From: [Downes, Scott G \(DFW\)](#)
To: [Jeremiah Cromie](#)
Cc: [Torrey, Elizabeth M \(DFW\)](#)
Subject: RE: RU-22-00005 Kostanich - Notice of Application WDFW Comments
Date: Monday, November 28, 2022 11:30:56 AM

Subject: RU-22-00005 Kostanich - Notice of Application

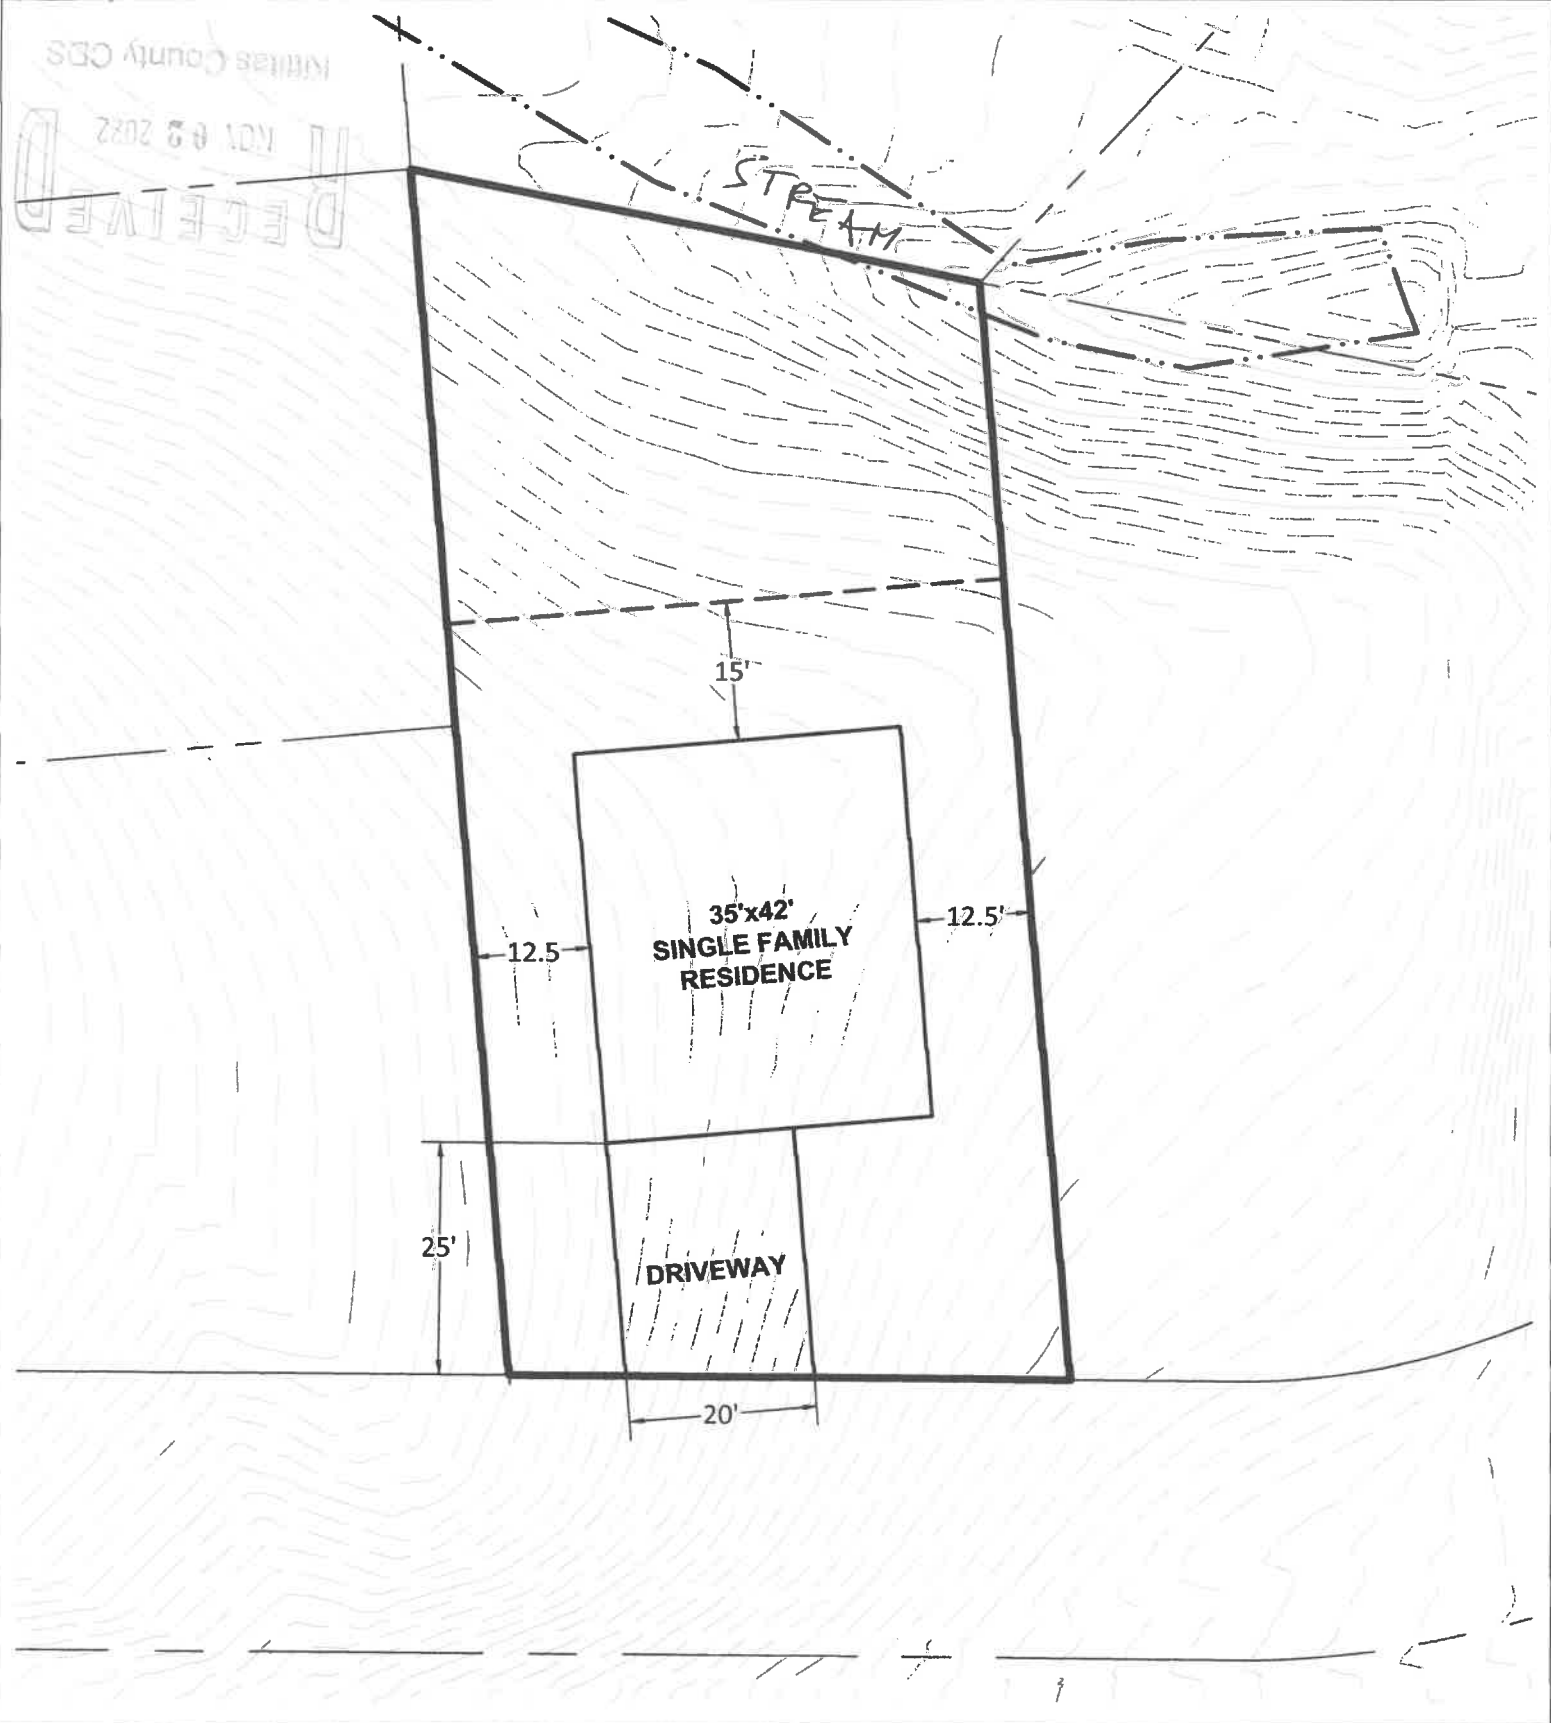
Thank you for the clarification. WDFW does have significant concern with building so close to a Type F (fish habitat). WDFW would not be in support of approving this application without a mitigation plan that ensures there is no net loss of riparian function and habitat. WDFW does not agree with the CAO report that placing a single family residence here (within 50 foot of a Type F creek) will have no negative impact. Further at this site, across the creek, there is also riparian impacts planned (that have been mitigated) through the Ski Acres proposed development. While we appreciate that they have kept the home small, could their site plan include reduction in driveway setback so that they could setback further from the creek.

1. The applicant does not show on his site plan the distance to the stream edge to allow for comment on how far proposed setbacks from the creek would be. WDFW would like to see this distance prior to any approval and before the comment deadline in case we may need to make further comment.
2. The applicant should be submitting a mitigation plan for potential impacts to the riparian area

from encroachment due to the building. That mitigation plan should include strategies to offset any loss of riparian function from vegetation (trees, shrubs) lost from the clearing. Once a mitigation plan is prepared, WDFW would like to review and comment and if necessary meet on site to discuss prior to approval of a mitigation plan. WDFW requests that this mitigation plan be a condition of an approval.

The site plan is scaled and scaled correctly. I did a quick measure and it looks like the nearest point of the proposed residence is 44 feet from the stream (see attached pdf). That should help with your first comment and any subsequent comments that result.
